Subject: FW: FG/48/18/DOC Onslow Caravan Park, Ferring

Please see Drainage Engineer's comments in red

The Drainage Engineer has stated relating to Condition 4 Drainage:

Scale 1:250 Date 03.11.17 Drawing No 100 A

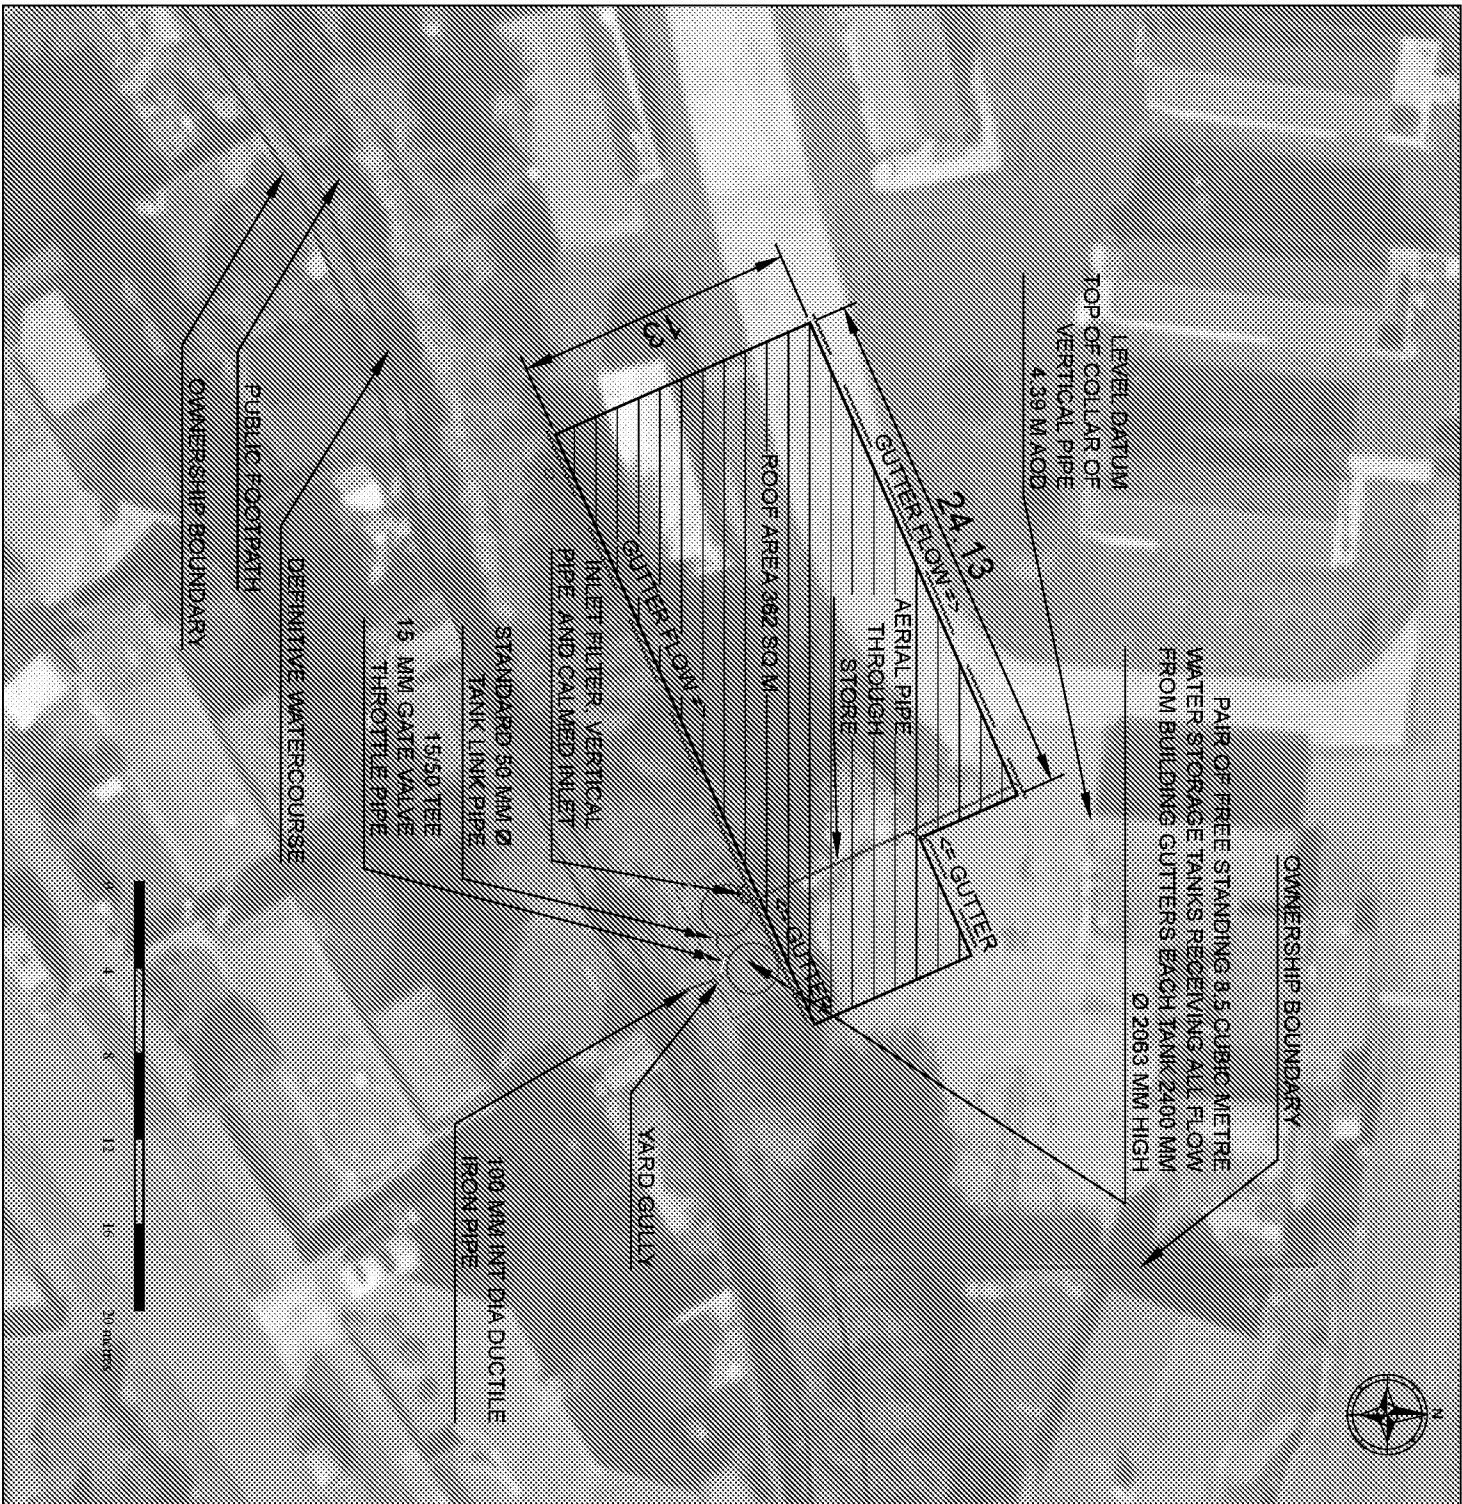
- It is noted that only a 20% allowance for climate change has been included in the design of the surface water drainage system. This needs to be increased to 30% in line with the condition applied. THE 20% ALLOWANCE ACCORDS WITH PLANNING PRACTICE GUIDANCE FOR THE LIFETIME OF THE DEVELOPMENT PROPOSED, AND ALSO WITH THE CENTRAL ALLOWANCE FOR RESIDENTIAL DEVELOPMENT. 30% IS NOT JUSTIFIED. THE CONDITION APPLIED TO THE APPLICATION (EMAIL 10/04/17) IS 30% ALLOWANCE FOR CLIMATE CHANGE. THEREFORE, 30% ALLOWANCE HAS TO BE USED.

- The restriction size of 20mm is of concern regarding the possibility of blockage. It is recommended that a mesh or similar is installed within each tank at the face of the outlet. THE INLET STRAINER IS SUPPLIED TO PREVENT LARGE PARTICLES ENTERING THE TANKS. FLOW RATES THROUGH THE OUTLET ARE SO LOW THAT IF GROWTH OCCURS WITHIN THE TANKS, IT WOULD NOT TEND TO BE DRAWN TOWARDS THE OUTLET, WHICH HAS THE ABILITY TO PASS 15 MM PARTICLES. IF A BLOCKAGE WERE TO OCCUR, IT WOULD SPOTTED QUICKLY AND WOULD BE EASY TO REMOVE. WHEREAS THE TEE COULD BE CHANGED AND A 1 1/2" BSP STRAINER ADDED, ALLOWING EASY MAINTENANCE, SUCH A STRAINER IS LIABLE TO BLOCKAGE WITH SMALL PARTICLES. THEREFORE NO STRAINER IS

RECOMMENDED. A MESH SCREEN WITHIN THE TANKS AS SUGGESTED WOULD BE VERY DIFFICULT TO MAINTAIN AND THUS ALSO IS NOT RECOMMENDED. OKAY. HOW FREQUENTLY WILL THE INLET STRAINER BE INSPECTED AND CLEANED?

- It is currently proposed that the outlet to the existing ditch will be formed by a paving slab. This is not acceptable, we require a formal headwall to be formed using concrete bags or brickwork. With full construction detail drawings to be supplied and approved by us. THE OUTLET PIPE IS DUCTILE IRON WITH A FLAP ATTACHED. AS SUCH THE OUTLET IS RESILIENT TO DAMAGE AND BARELY ANY DISTURBANCE OF THE BANK WILL OCCUR. A HEADWALL IS ENTIRELY UNNECESSARY. THE PROPOSED PAVING SLAB CAN BE OMITTED. A HEADWALL IS REQUIRED TO ENSURE THAT THE CONTINUED IDENTIFICATION AND MAINTENANCE OF THE OUTLET IS EASY. OUTLETS WITHOUT HEADWALLS ARE FREQUENTLY LOST AND MAINTENANCE OF THE DITCH IS MORE DIFFICULT. THEREFORE, A HEADWALL WILL BE REQUIRED.

- Full construction details will be required including the gully/headwall, any manholes, and silt traps. DRAWING 100A ALREADY SHOWS EVERY DETAIL NECESSARY TO BUILD THE UNDERGROUND DRAINAGE. NO OTHER DETAIL COULD BE REQUIRED. PLEASE PROVIDE CONSTRUCTION DETAILS OF THE GULLY AND HEADWALL.
